**SSD 6010 - One Residential Building (Student Accommodation) within
Darling Drive Plot**

Submission by:

Christophorus Susanto

26 July 2013

SICEEP - SSDA3 Shadow Study

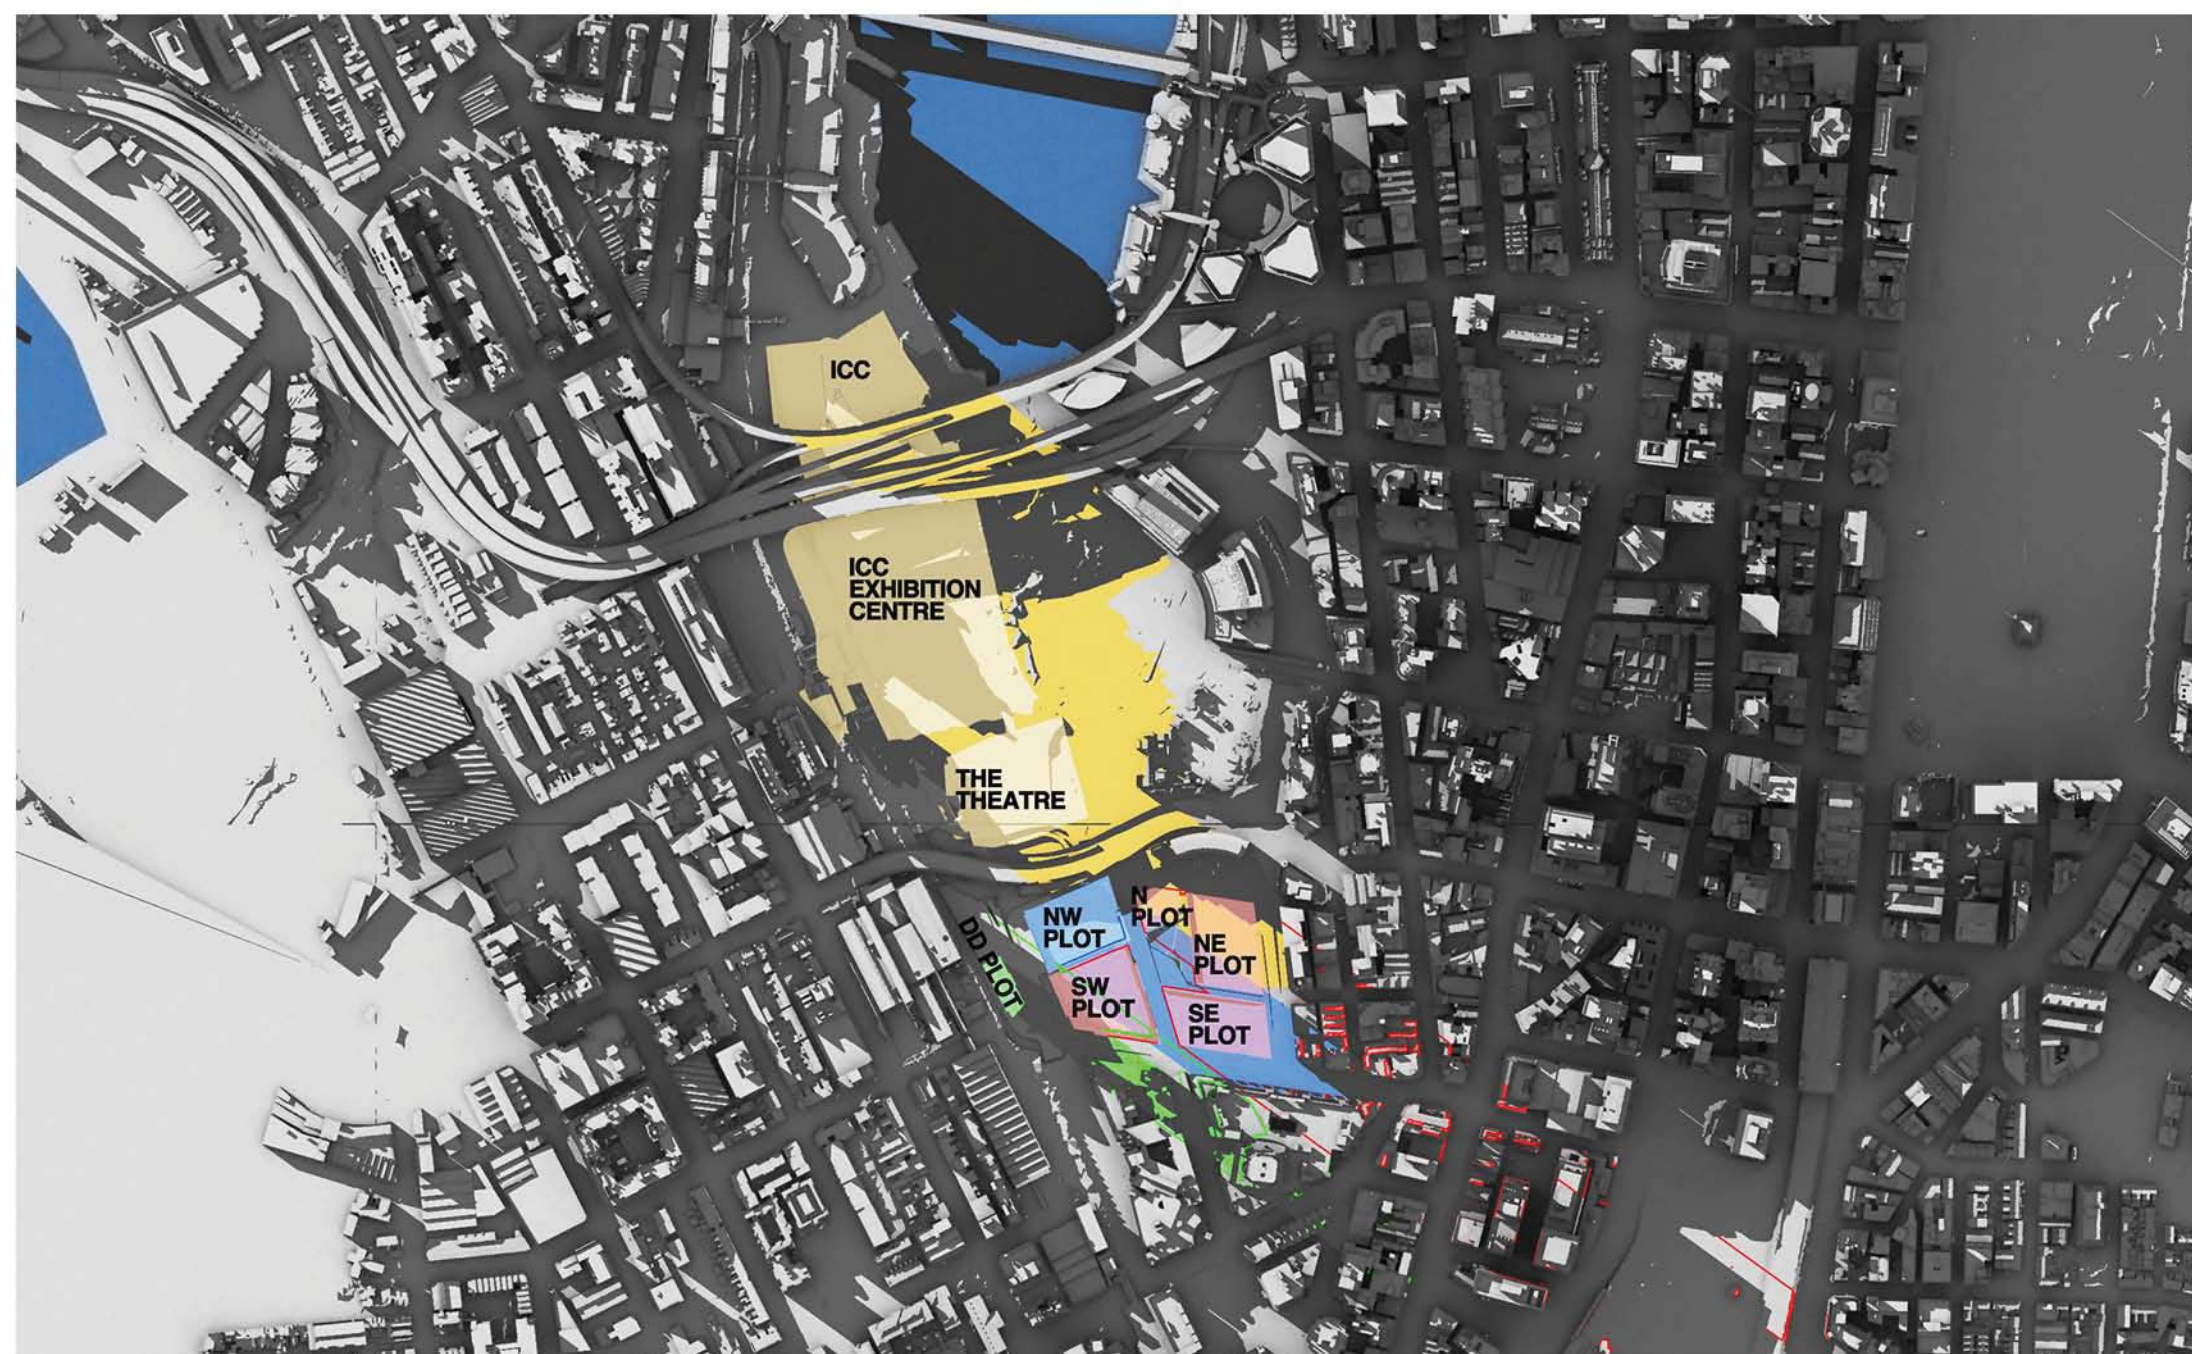
The proponent provides diagrams but fails to discuss the existing shadowing of the west façade of The Peak.

At 9am, 10am and 11am the west façade is totally in shadow due to other parts of The Peak building itself.

At 12pm there is still substantial existing shadowing on the west façade caused by the irregular shape of the west facade.

At 1pm the existing shadowing has been substantially removed, but not totally removed.

It can be concluded that some single aspect apartments on the west façade and some south-west dual aspect corner apartments currently receive less than 2 hours direct sunlight to habitable rooms and 50% of the private open space between 9am and 3pm on 21 June.

By 2pm the existing shadowing has been totally removed, but that is too late to achieve two hours of direct sunlight before 3pm.

At 9am, 10am and 11am the west façade is totally in shadow due to other parts of The Peak building itself.

At 12pm there is still substantial existing shadowing on the west façade caused by the irregular shape of the west facade.

At 1pm the existing shadowing has been substantially, although not entirely, removed. However, overshadowing of lower levels of the west façade by the concept proposal parameter plan shadows for the N,NE and SE plots has already started.

By 2pm the existing shadowing has been totally removed. However, overshadowing of the west façade by the SSDA4 and SSDA5 buildings has appeared and risen further up the west façade than the concept proposal parameter plan shadows for the N,NE and SE plots, which is still present.

At 3pm, the proponent states correctly that 45-45% of the western façade is overshadowed by the SSDA4 and SSDA5 buildings.

It can be concluded that, as a result of combination of the proposed development with existing shadowing of the west façade, some single aspect apartments on the west façade and the south-west dual aspect corner apartments which currently receive less than 2 hours direct sunlight to habitable rooms and 50% of the private open space between 9am and 3pm on 21 June will suffer additional overshadowing. It is beyond our skills to count the number of such apartments. We note that the proponent has made no attempt to do so.

Rather than counting the number of units which will not meet the DCP guidelines, the proponent attempts to trade-off direct sunlight at 4pm for lack of direct sunlight during the period 9am to 3pm. There is no provision in the DCP guidelines for such a trade-off.

SHADOW DIAGRAMS: PERSPECTIVE, SHOWING THE PEAK, WINTER SOLSTICE

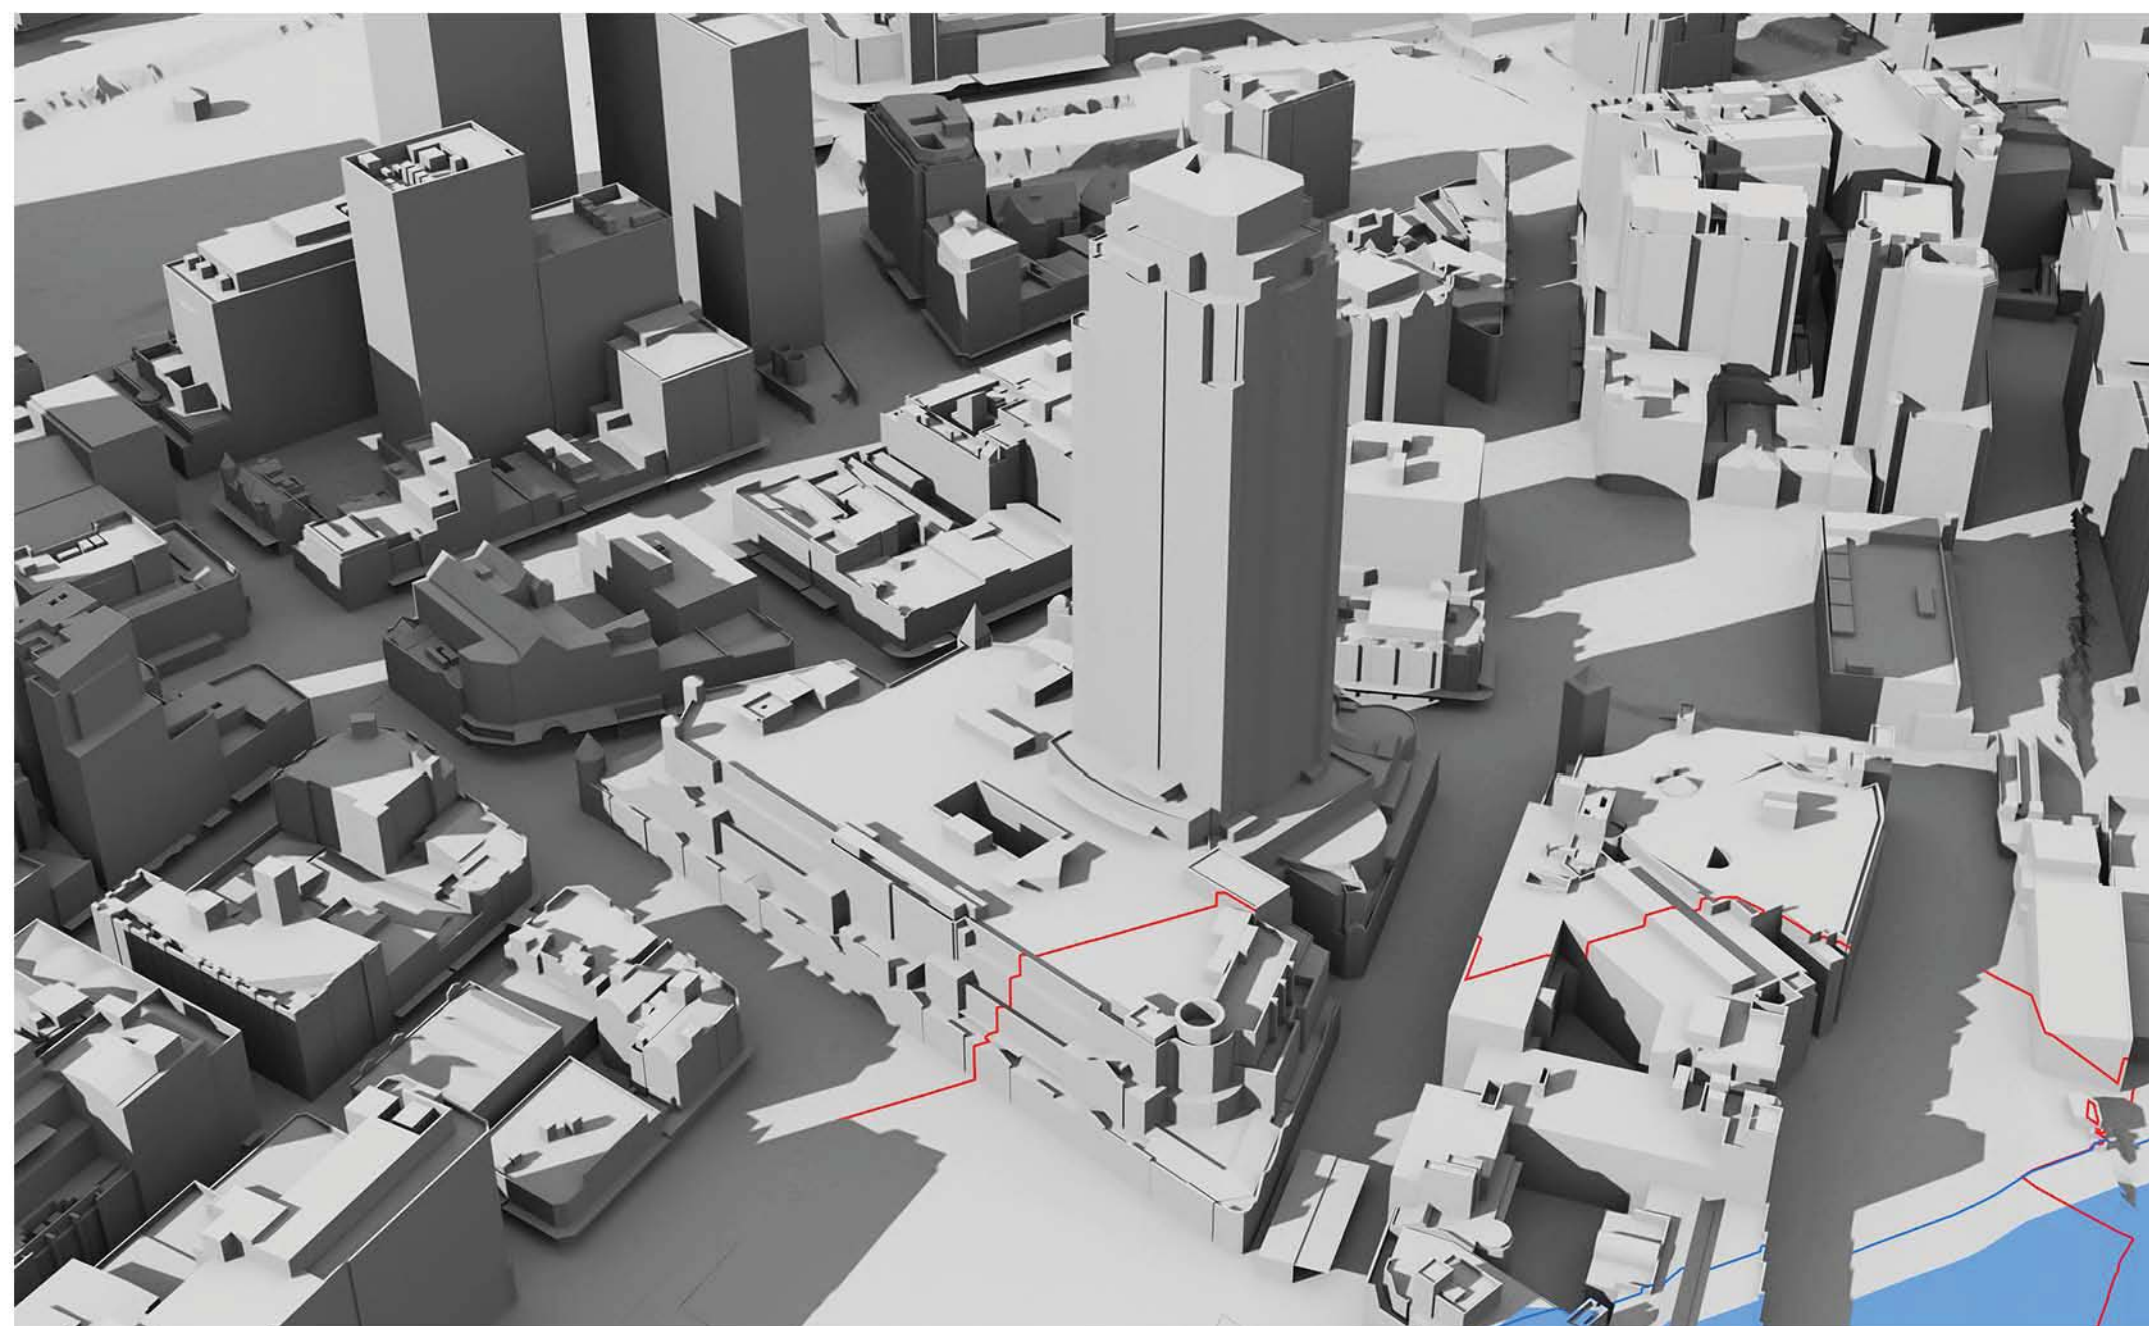
Proponent statement	Location of statement	Actual fact
<i>At mid-winter (22 June) there is some additional overshadowing impact to the Markey City podium and to the western elevation of The Peak Apartments after 2 pm. There is no additional overshadowing during the morning period, or the early afternoon.</i>	SSD5878 Response to Submissions and Amendments to Proposed Development Report, July 2013, Section 2.8 Overshadowing	That statement is misleading; in fact the podium additional overshadowing starts at 9 am and increases throughout the morning and early afternoon.
<i>At mid-winter (22 June) By 4pm, approximately 45-50% of the western elevation is in shadow, however the shadow has substantially moved off the northern façade such that only approximately 15-20% of the façade remains in shadow.</i>	SSD5878 Response to Submissions and Amendments to Proposed Development Report, July 2013, Section 2.8 Overshadowing	That statement is false, as can be seen from the diagram. The proponent has confused the western and northern facades.

<i>All apartments in The Peak tower will continue to receive solar access for more than 2hrs during midwinter.</i>	SSD5878 Response to Submissions and Amendments to Proposed Development Report, July 2013, Section 2.8 Overshadowing	The proponent fails to address the direct sunlight specifically between 9am and 3pm as per the DCP guidelines.
<i>It is also noted that the apartments on the northern and western elevations of the building are dual aspect.</i>	SSD5878 Response to Submissions and Amendments to Proposed Development Report, July 2013, Section 2.8 Overshadowing	Many apartments on the northern and western elevations are single aspect only. See detailed discussion in Sections 4 and 5 below.
<i>At mid-winter (22 June) As the afternoon progresses the length and extent of shadow increases and by approximately 3pm approximately 40-45% of the western and northern tower elevations are overshadowed. By 4pm, approximately 45-50% of the western elevation is in shadow, however the shadow has substantially moved off the northern façade such that only approximately 15-20% of the façade remains in shadow.</i>	SSD5878 Appendix G. Response to Public Submissions. Proponent's Response	That statement is false, as can be seen from the diagram. The proponent has confused the western and northern facades.

<i>The extent of additional overshadowing to the northern and western elevations of The Peak is considered appropriate and reasonable. All apartments in The Peak tower will continue to receive solar access for more than 2hrs during midwinter.</i>	SSD5878 Appendix G. Response to Public Submissions. Proponent's Response	The proponent fails to address the direct sunlight specifically between 9am and 3pm as per the DCP guidelines.
<i>It is also noted that the apartments on the northern and western elevations of the building are dual aspect.</i>	SSD5878 Appendix G. Response to Public Submissions. Proponent's Response	Many apartments on the northern and western elevations are single aspect only. See detailed discussion in Sections 4 and 5 below.

Proponent statement	Location of statement	Actual fact
Winter solstice - 22 June <i>9:00 - 1.00 NO IMPACT</i>	SSD5878 Appendix H. Supplementary Design Report, Section 6. Amendments Winter solstice - 22 June	That statement is false; in fact the podium roof additional overshadowing starts at 9 am and increases throughout the 9 am to 1 pm period (and continues to increase thereafter)
Winter solstice - 22 June <i>2:00 – The western edge of the Market City podium roof is overshadowed</i>	SSD5878 Appendix H. Supplementary Design Report, Section 6. Amendments Winter solstice - 22 June	Most of the western and northern podium roof is overshadowed.
Winter solstice - 22 June <i>3:00 – The Market City podium roof is overshadowed from the north west corner to the Peak Tower;</i>	SSD5878 Appendix H. Supplementary Design Report, Section 6. Amendments Winter solstice - 22 June	Almost the entire podium roof is overshadowed.

Winter solstice - 22 June <i>4:00 – The Market City podium roof is overshadowed from the north west corner to the in front of the north elevation of the Peak Tower;</i>	SSD5878 Appendix H. Supplementary Design Report, Section 6. Amendments Winter solstice - 22 June	True, and this has substantially been the case since 2pm.
Winter solstice - 22 June <i>4:00 – 15-20% of the Peak Tower northern elevation remains in shadow since 3pm;</i>	SSD5878 Appendix H. Supplementary Design Report, Section 6. Amendments Winter solstice - 22 June	Actually 45-50% of the Peak Tower northern elevation remains in shadow since 3pm.
Winter solstice - 22 June <i>4:00 – A portion of the Peak Tower north elevation (15-20%) now receives direct sunlight when compared to the maximum building envelope model – portions of which were previously overshadowed at 3pm.</i>	SSD5878 Appendix H. Supplementary Design Report, Section 6. Amendments Winter solstice - 22 June	The reduction compared with the maximum building envelope model can be seen from the diagram to be only about 5-10%.
